Address: The Old Dewsbury Library, Wellington Road, Dewsbury, WF13 1HN

Application Ref: 2025/65/92140/E

Proposal: Listed Building Consent for alterations to former library to form 14 apartments with associated internal and external works (within a Conservation Area)

GROUND FLOOR PLAN
1:100

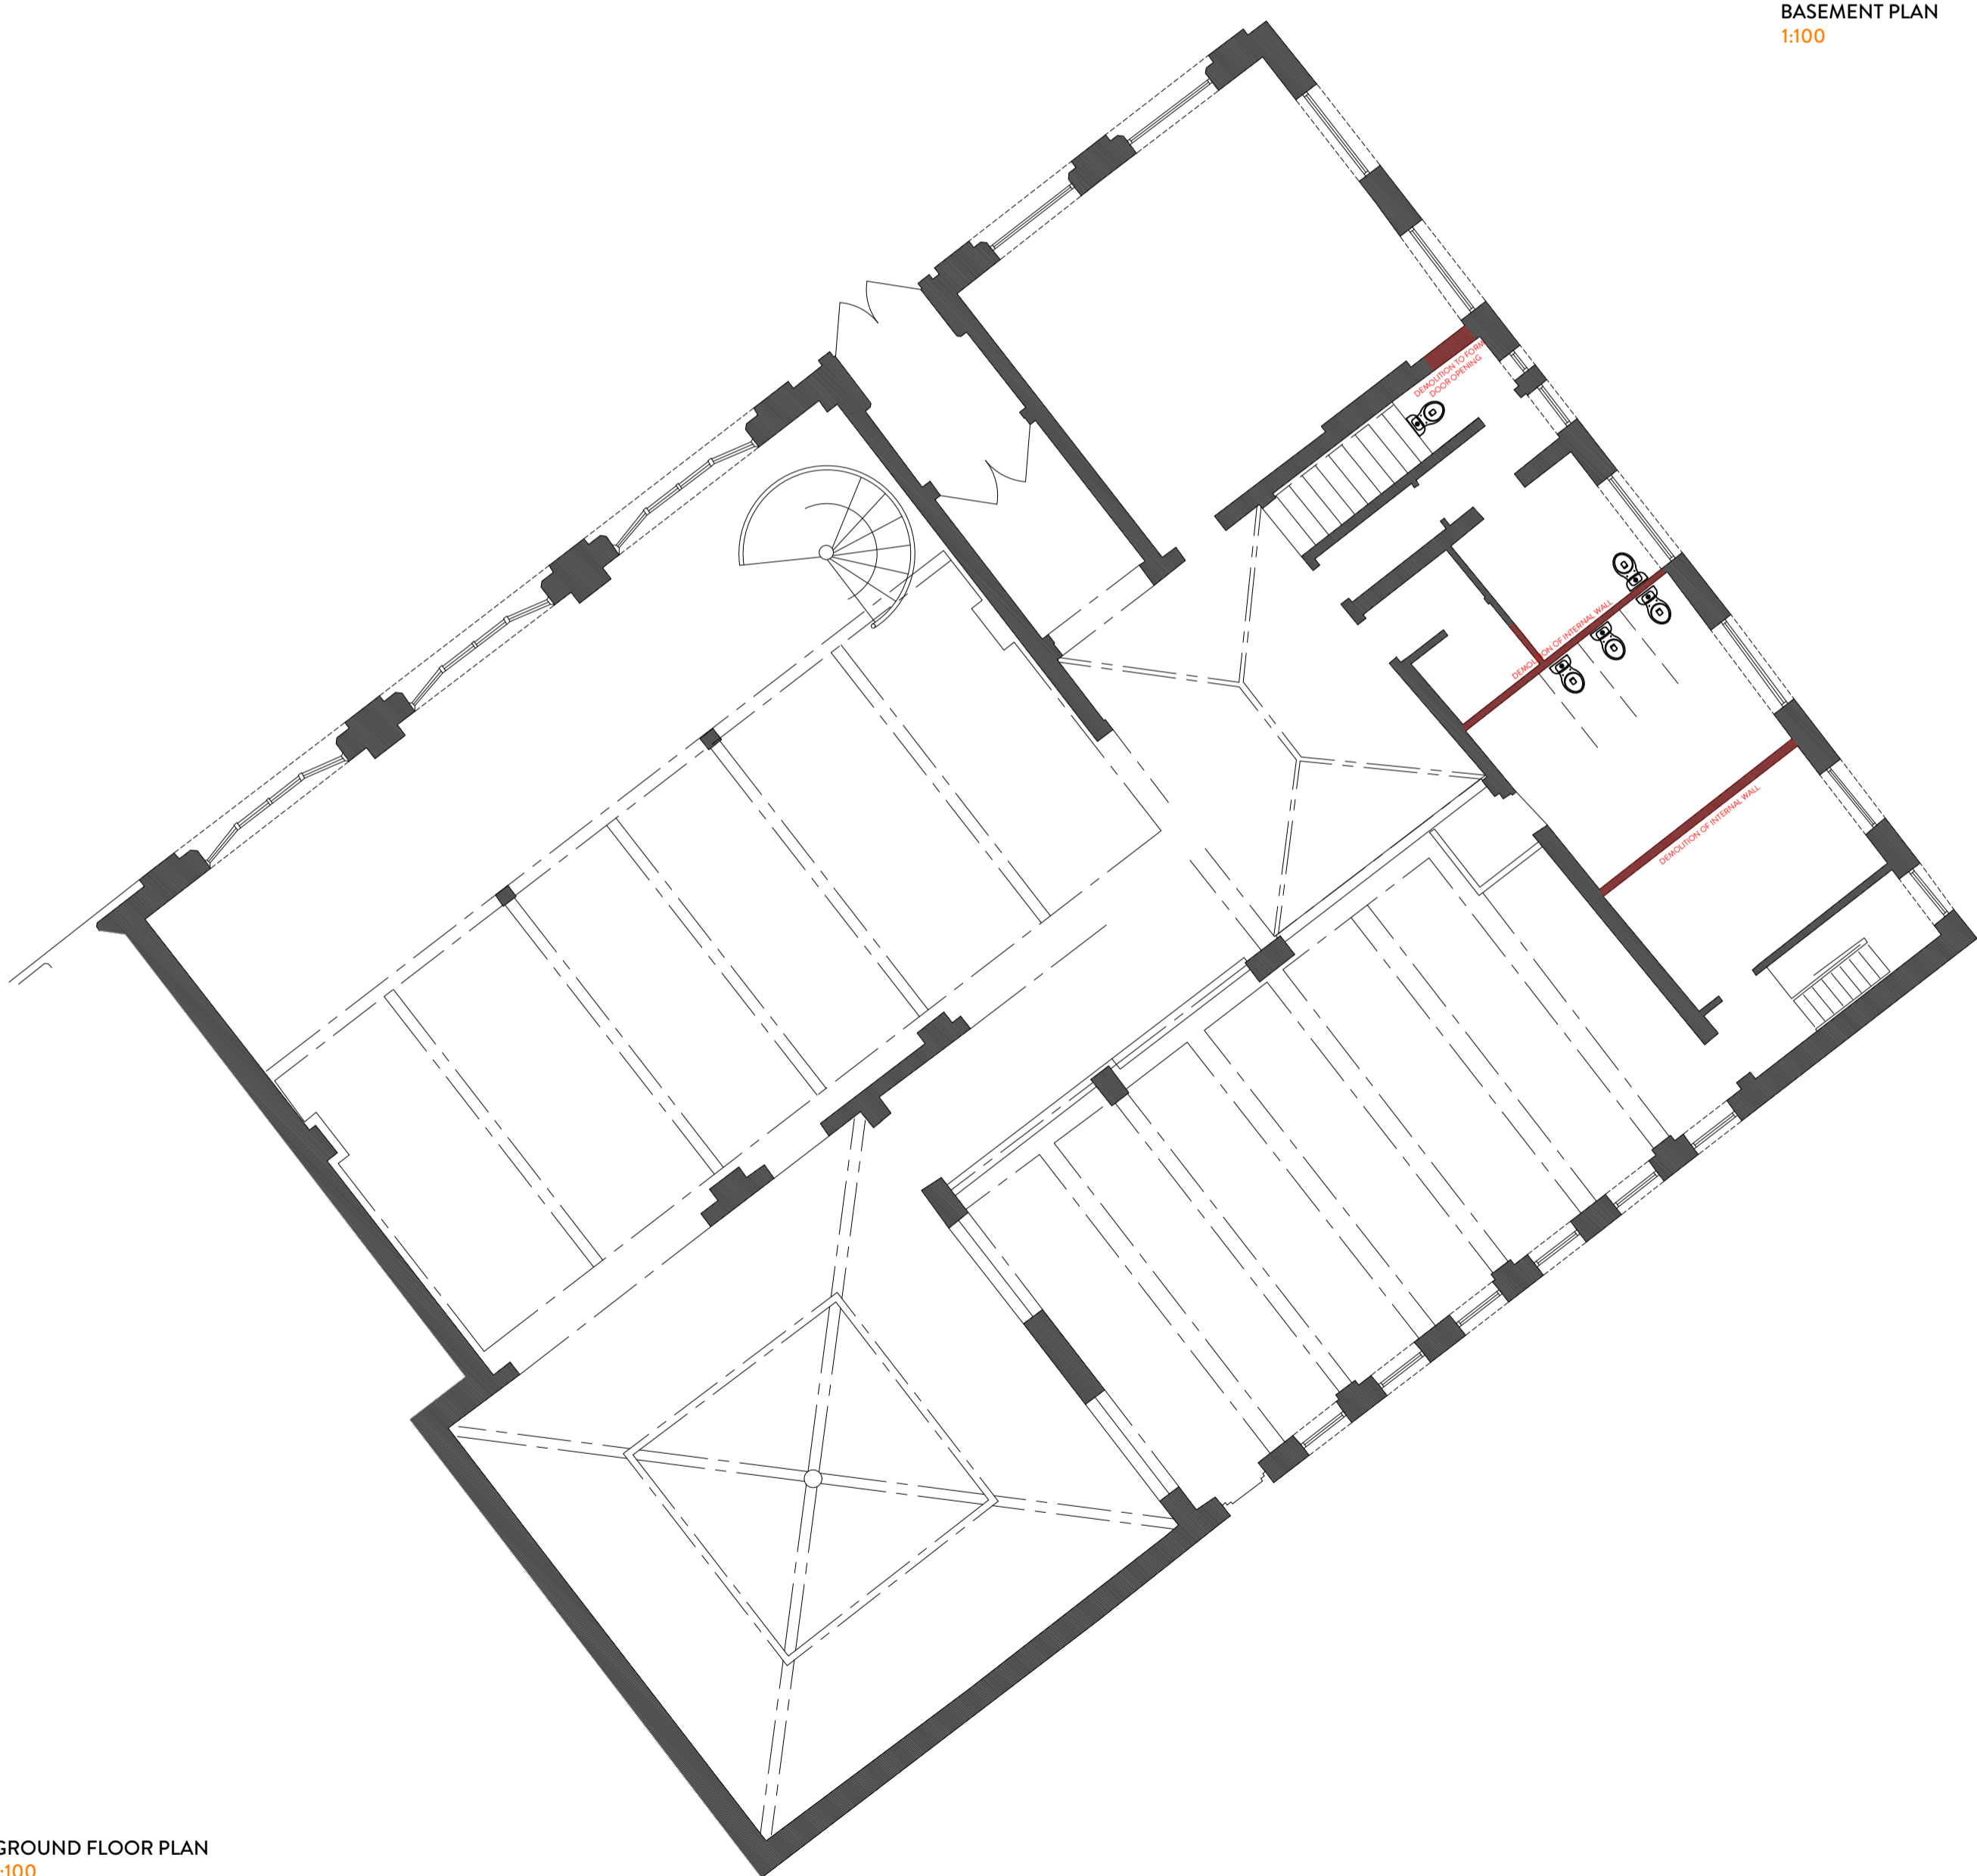
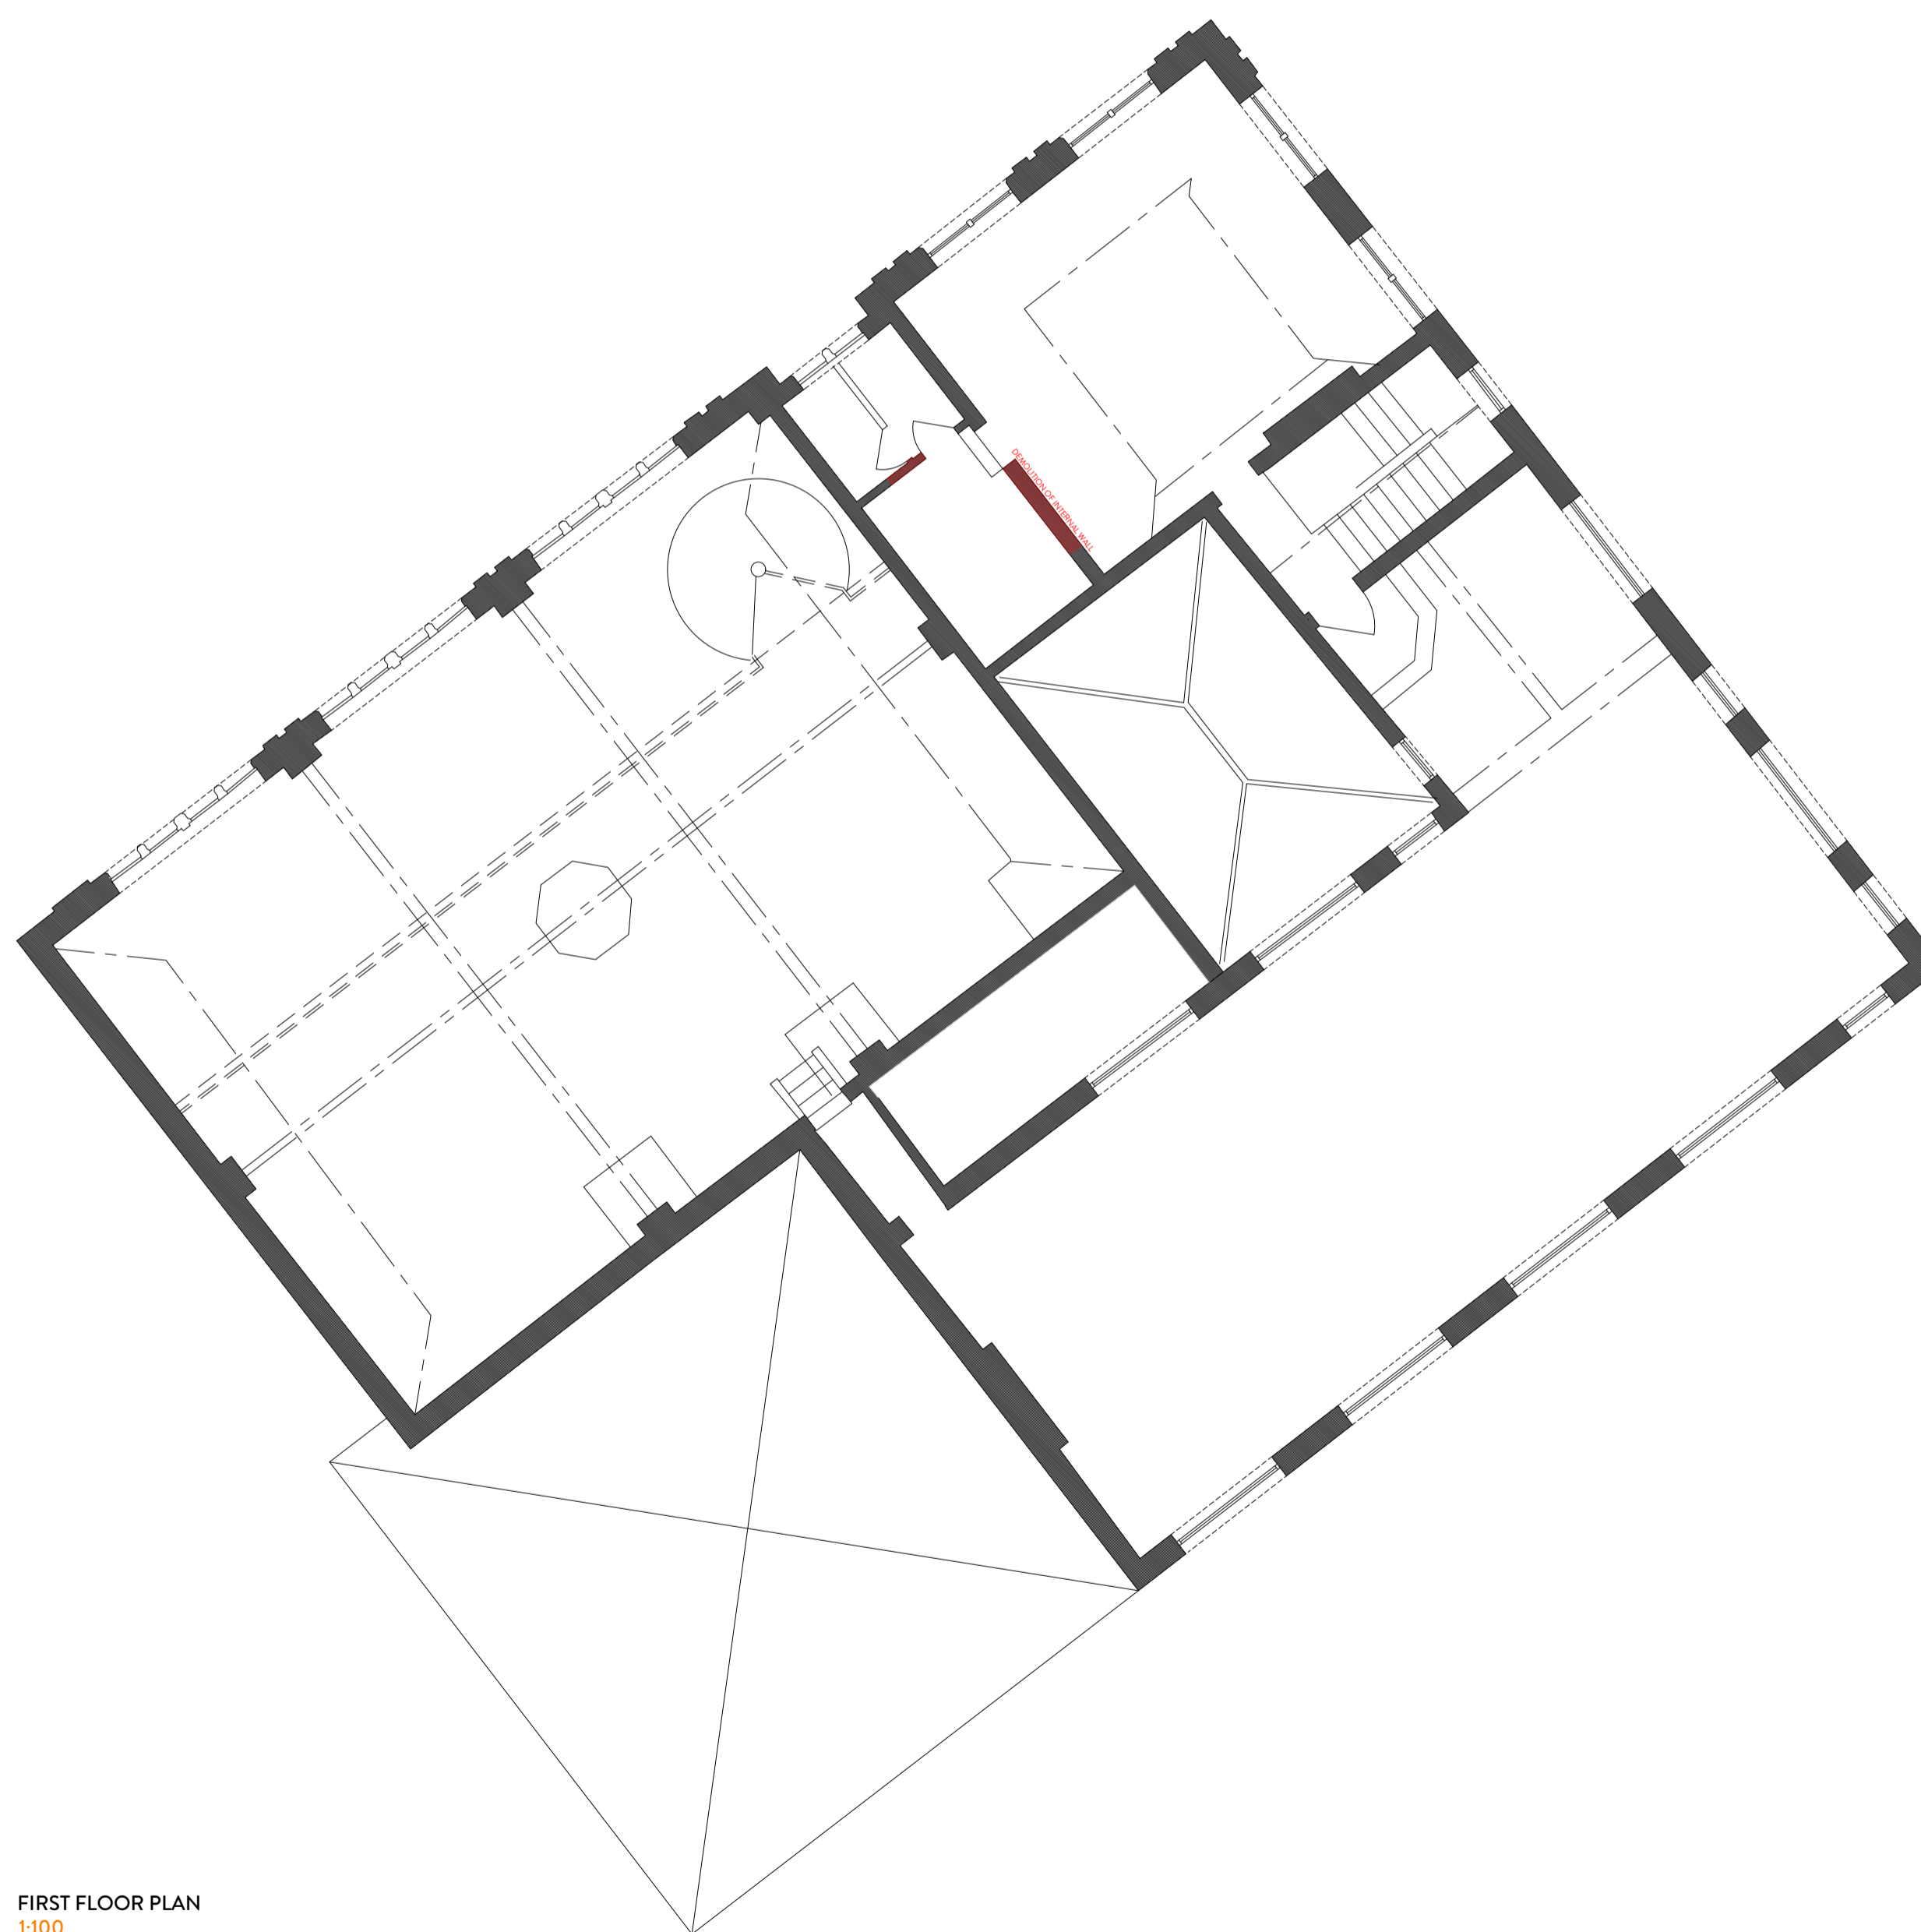
- Given the various changes to the floor levels and styles of ceiling (domed, barrel vaulted, etc.) section plans are essential to show the impact of the alterations.
- While the horizontal subdivision of the front reading room is acceptable, and we note the floor plate meeting the new horizontal transom, the first-floor apartments need to be reordered and designed so that they do not intersect the top half of the arched windows at the mullions. This spoils the integrity of these feature windows both internally and externally. The apartment partitions should fit the existing ceiling trusses.
- It is assumed the wall tiling and dado panels will be retained, restored and refitted. Likewise, the front northern rooms with the fireplace. This needs to be

- The rear domed room with the top lit roof lantern is one of the principal spaces within the library. The plans suggest the room is to be horizontally subdivided with a false ceiling to separate the dome from the proposed flat. The plans and photos do not show any existing windows and details of these are needed. HB&P do object to the false ceiling as this alters the proportions and experience of this space. More creativity in the design is needed to respect and celebrate the architecture, rather than fight it, as the full height dome would make a wonderful open plan mezzanine living space.

- Where and how is the mural noted in the listing being moved to?
- The long room to the rear range as a shallow barrel-vaulted ceiling. How are the room partitions to interact with the curved ceiling? The room divisions should correspond with the existing sectional pattern of the ceiling. The stained glass in this room must also be retained in situ.
